## Ellicott Town Center Filing 2 Traffic Impact Study (LSC #194060) March 25, 2019

# Summary of Comments on LSC Responses to EPC TIS Redline Comments.pdf

Figure 4  
**2021 Baseline Traffic\*, Lane  
 Geometry, and Traffic Control**  
 Ellicott Town Center Rezone (LSC# 194060)

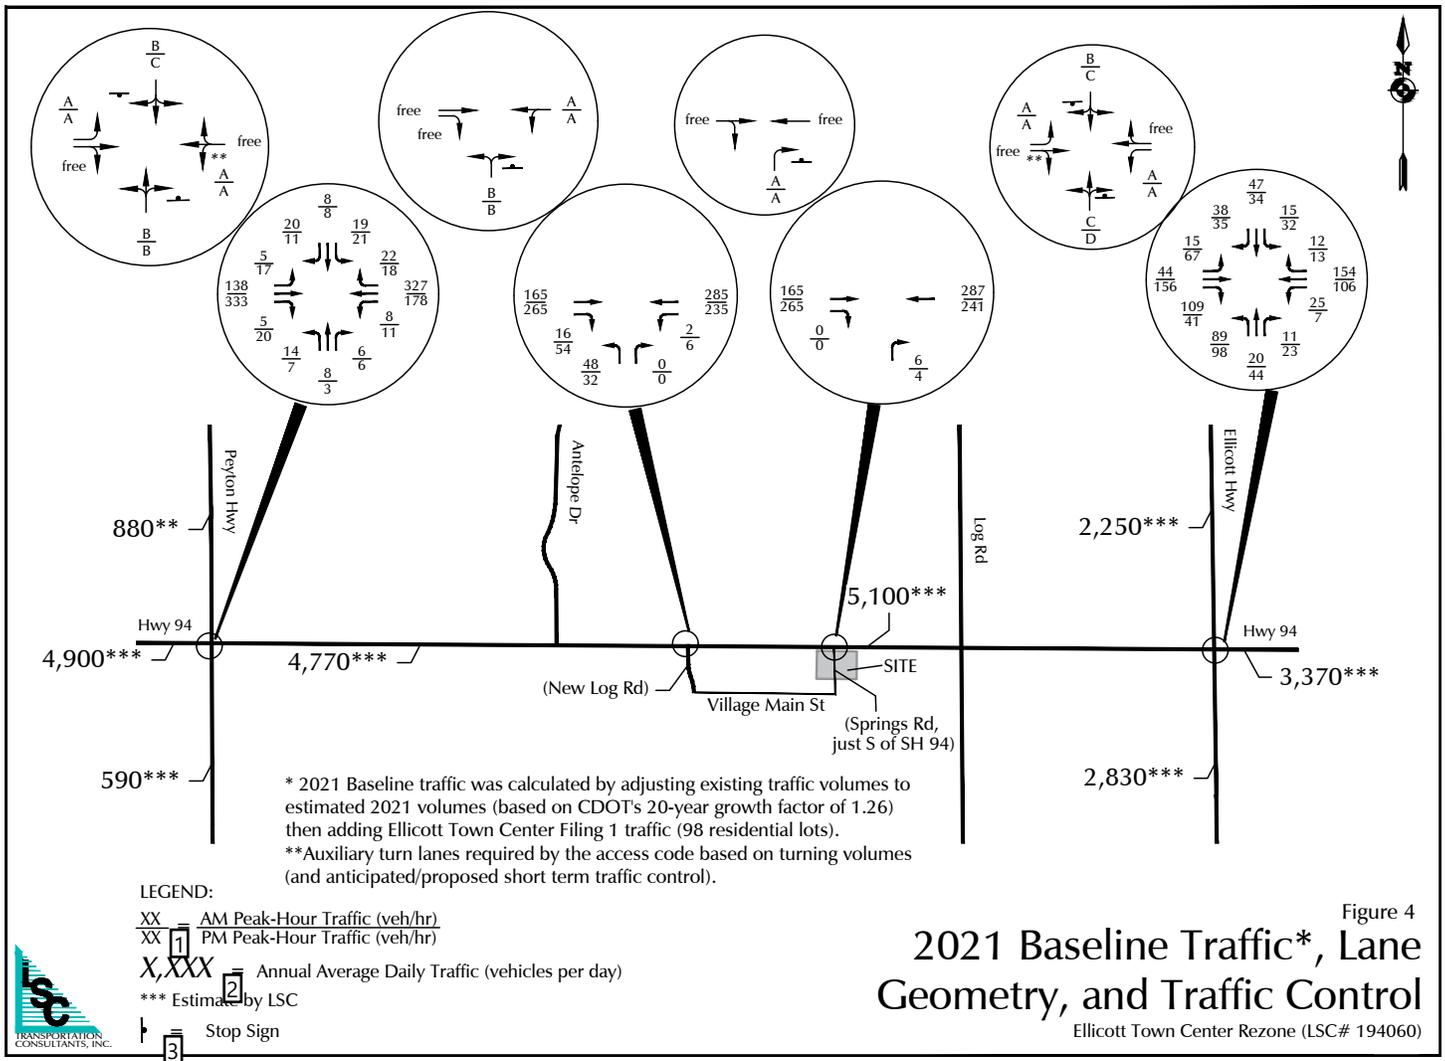
It seems unrealistic that no traffic from Filing 1 and 3 will be using this intersection for right turns. Please revise.

Please remove to avoid confusion as this is a RIRO only intersection as stated in narrative. Also remove from other applicable figures.

Please add :(now Filing 3) for clarity. Typical at other figures.

LSC Response: Revised as requested.

LSC Response: Removed as requested.

LSC Response: Added as requested.
